Subject: CPHR comments on Submissions and Amendment Report – WSU Indigenous Centre of Excellence (SSD-64916225)

CPHR flooding advice – Submissions and Amendment Report WSU Indigenous Centre of Excellence (SSD-64916225)

- *Submissions and Amendment Report Western Sydney University Indigenous Centre of Excellence* (Ethos Urban, 26 August 2025)
- *Western Sydney University Indigenous Centre of Excellence Flood Impact Risk Assessment* Version I (GRC Hydro, 24 July 2025) (FIRA)

Figure 27: Flood Level Impact – 1% AEP – Developed Condition

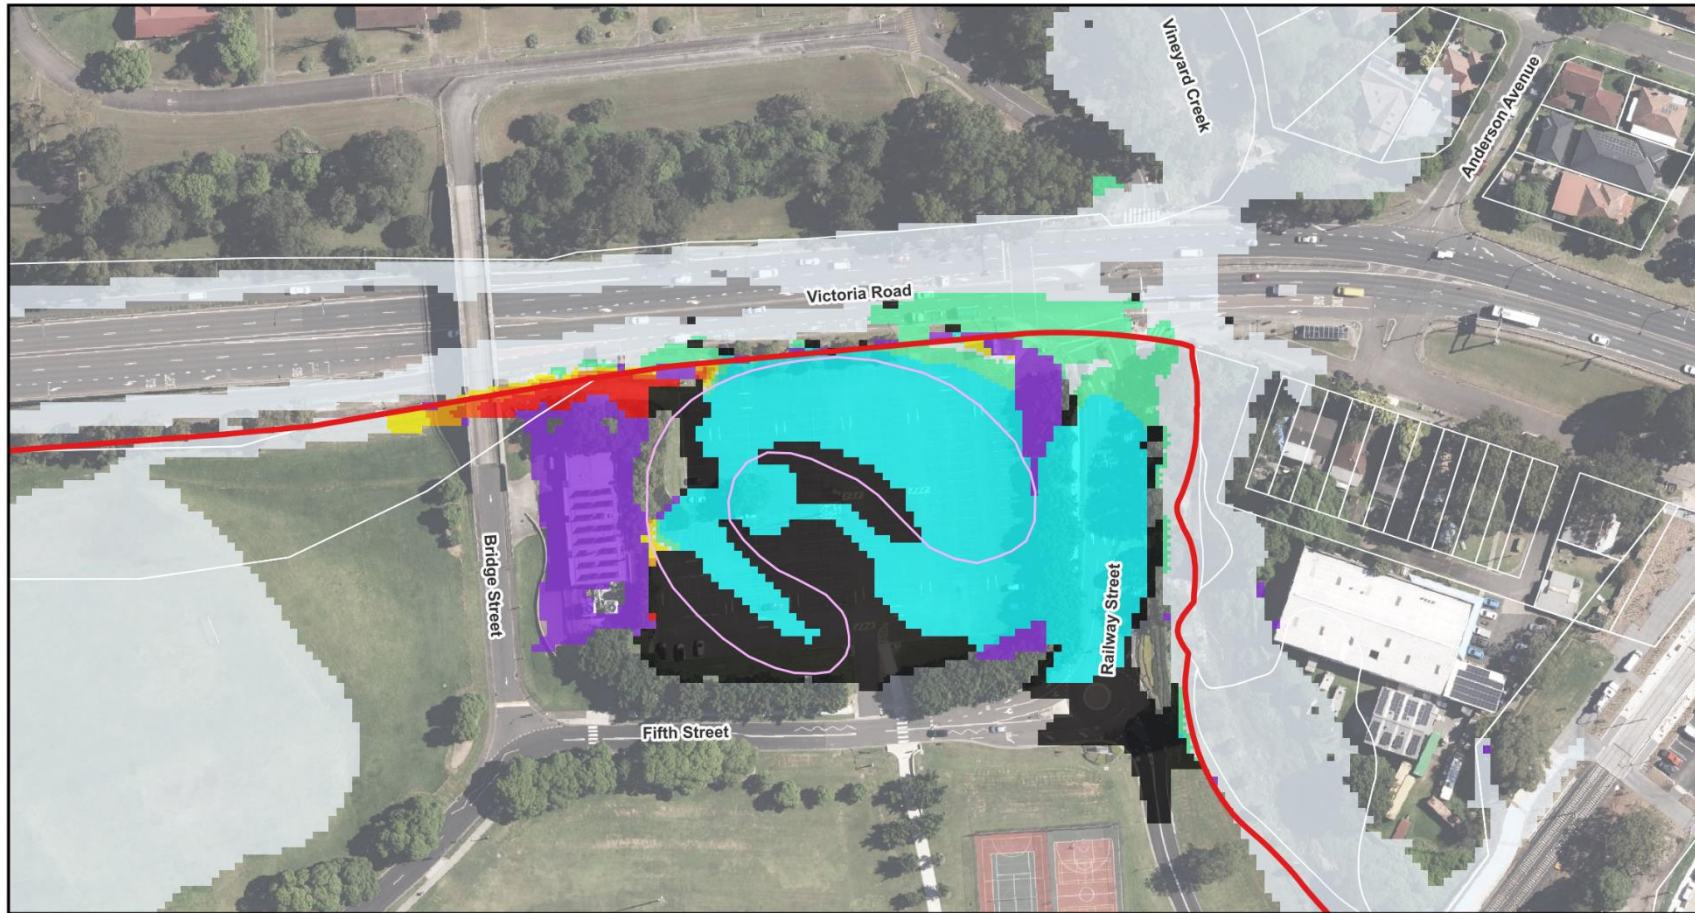
<i>Extent and Timing</i>	Pre-determination
2.	Flood impacts	CPHR previously requested consideration of flood impacts for the full range of flood events. Only the 1% Annual Exceedance Probability (AEP) flood event has been considered. Impacts for the 5% AEP flood event and the Probable Maximum Flood (PMF) should also be modelled to understand the impact of the development on flood behaviour for a range of flood events. Hazard mapping in the FIRA indicates that the development would increase hazard in the PMF. CPHR recommendation The FIRA is updated to consider flood impacts for the full range of flooding.
	<i>Extent and Timing</i>	Pre-determination

Figure 35: Peak Flood Levels and Depths – PMF – Developed Condition

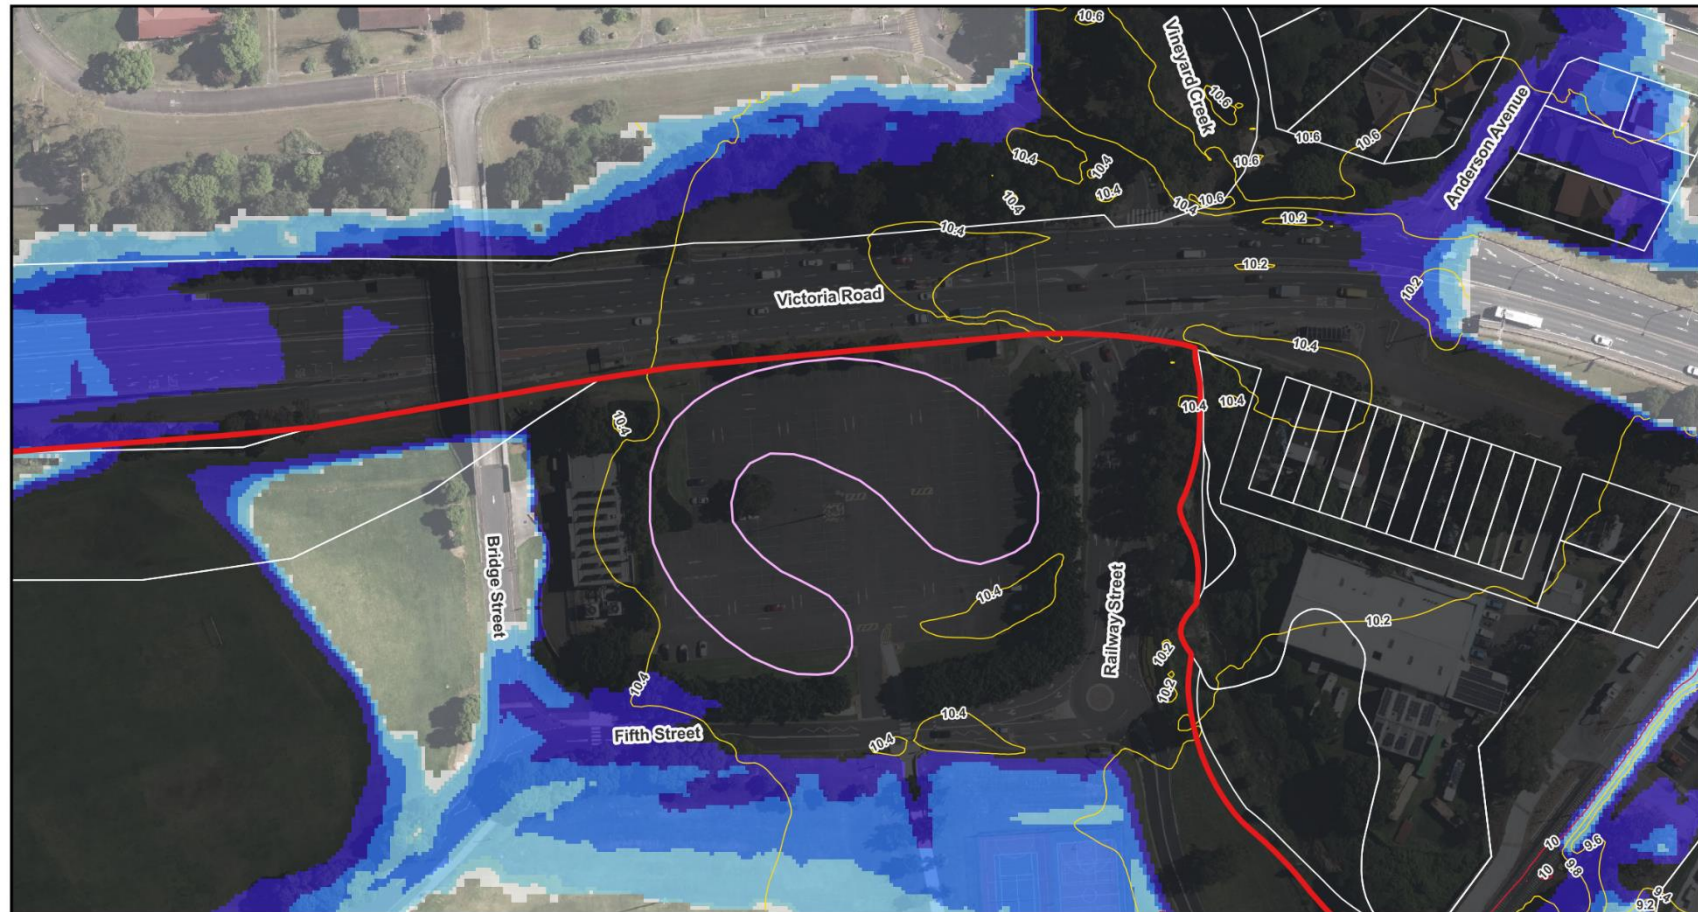
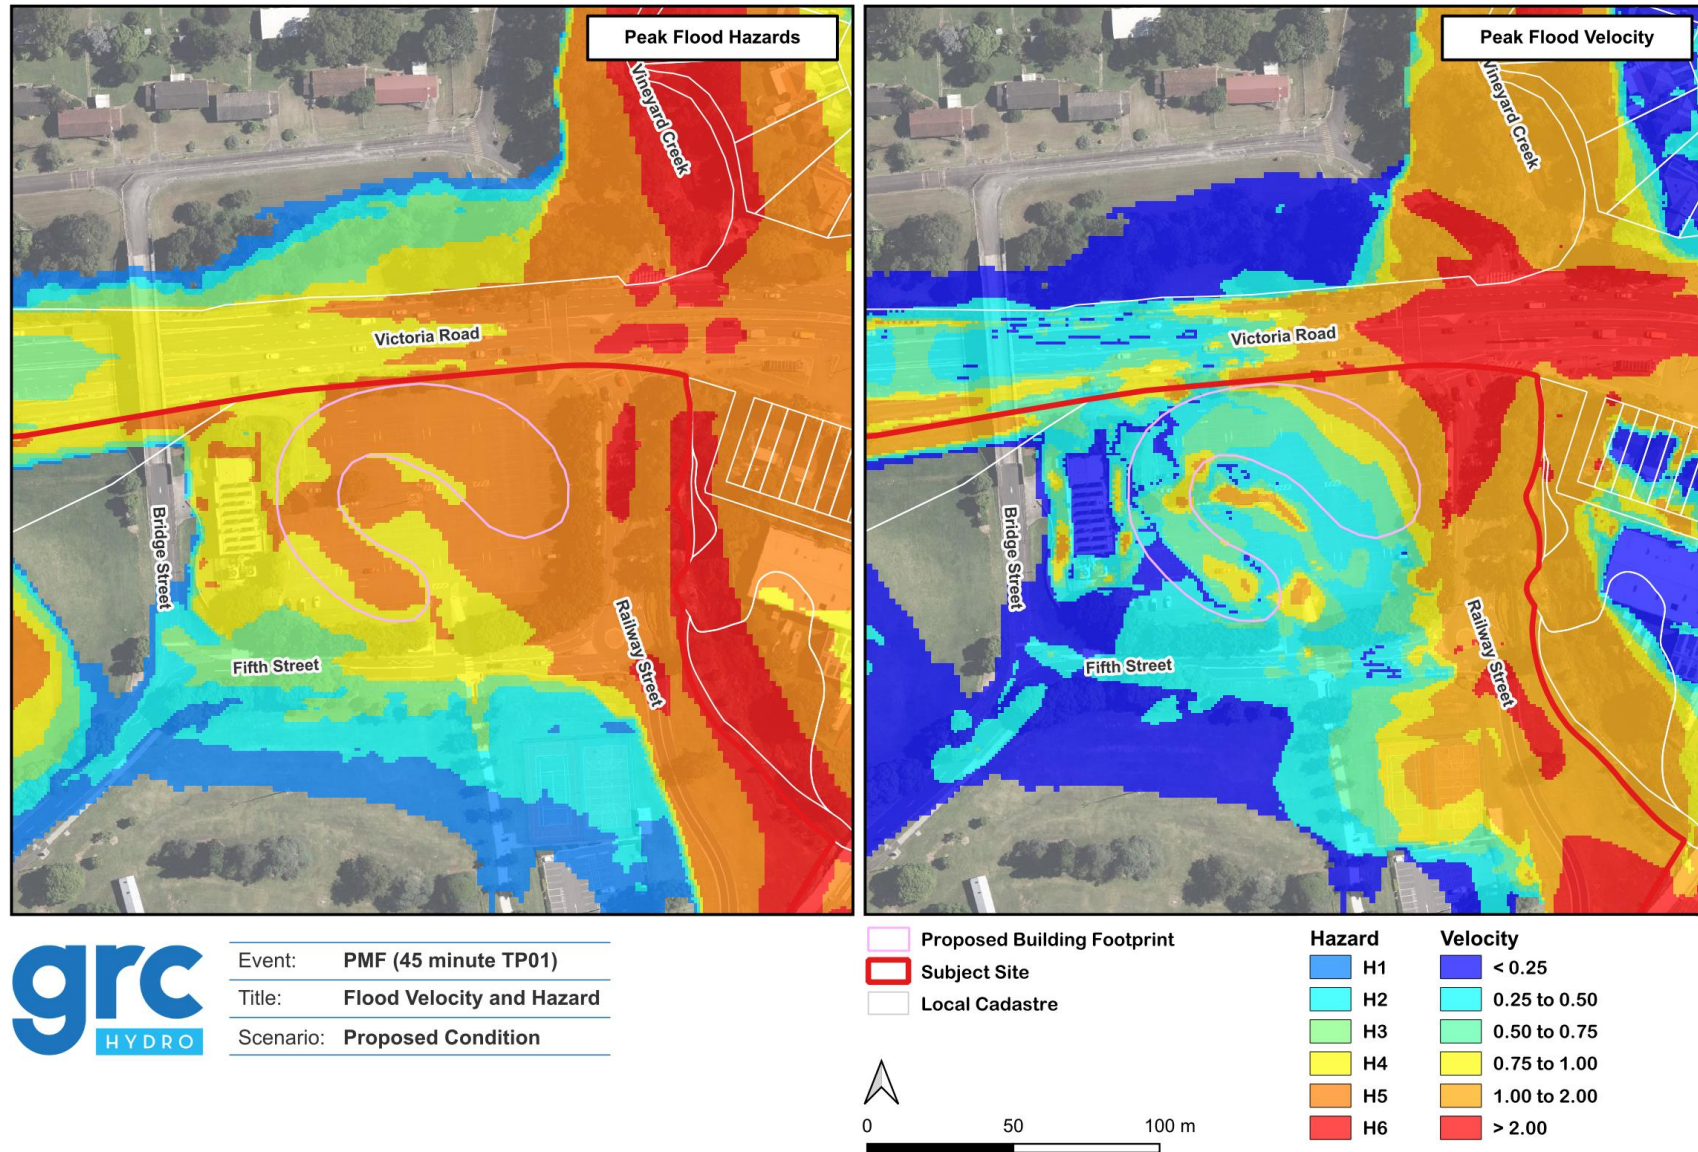
4.	Residual Risk and Emergency Management	In the PMF, floodwater from Vineyard Creek would inundate the ground floor to a depth in the order of 1.3m. The FIRA maps high hazard floodwater around the proposed building and on surrounding roads. The Parramatta River PMF would also isolate the site. CPHR previously recommended consideration of the time duration of isolation from a range of storm durations. CPHR anticipates that the duration of isolation could be over 12 hours, and this has been confirmed in another study. CPHR recommendation The consent authority considers the risk associated with high hazard flooding and the potential for long duration flooding.
	<i>Extent and Timing</i>	Pre-determination
